CITY OF ALBUQUERQUE

**Re: Volterra Village
1624, 1828, 1632 and 1636 Domino Rd SE
Request Permanent C.O. – Not Accepted
Engineer's Stamp dated: 9-30-09 (M21D015C)
Certification dated: 5-10-16**

CERTIFICATE OF SUBSTANTIAL COMPLIANCE

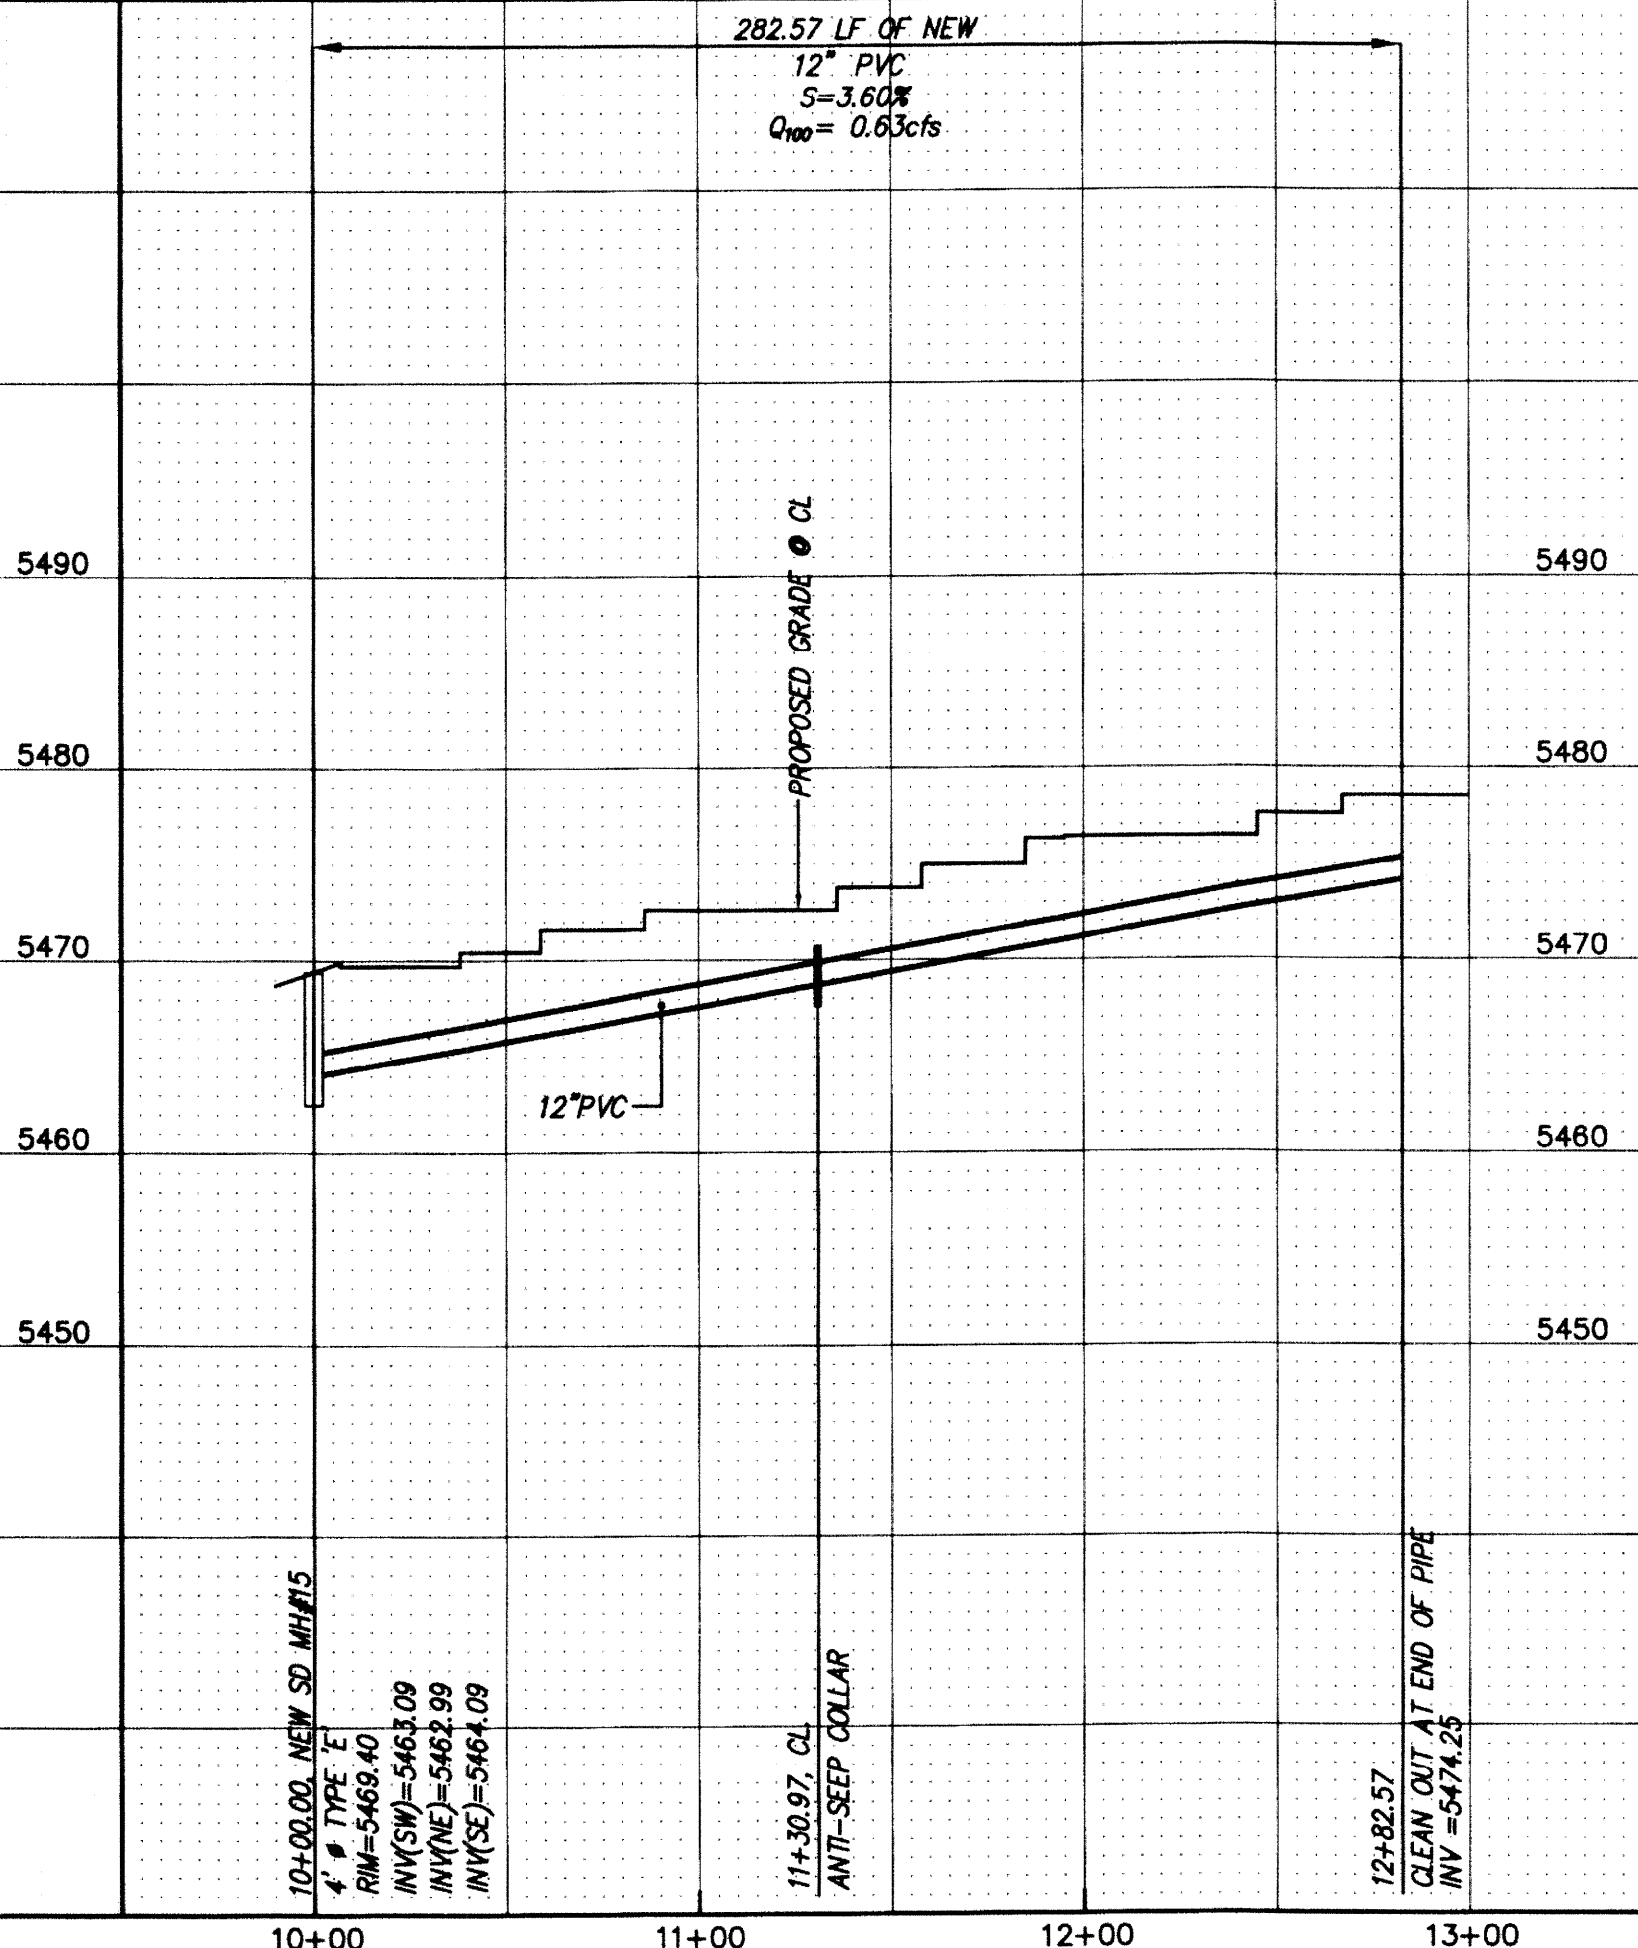
- The attached BP approval letter dated 9-10-14 states, "The drainage report required a 15" x 15" area drain in the courtyards". Per the attached pic the grates are 12" x 12". Please provide supplemental calculations that show the 12" x 12" in each courtyard is sufficient.
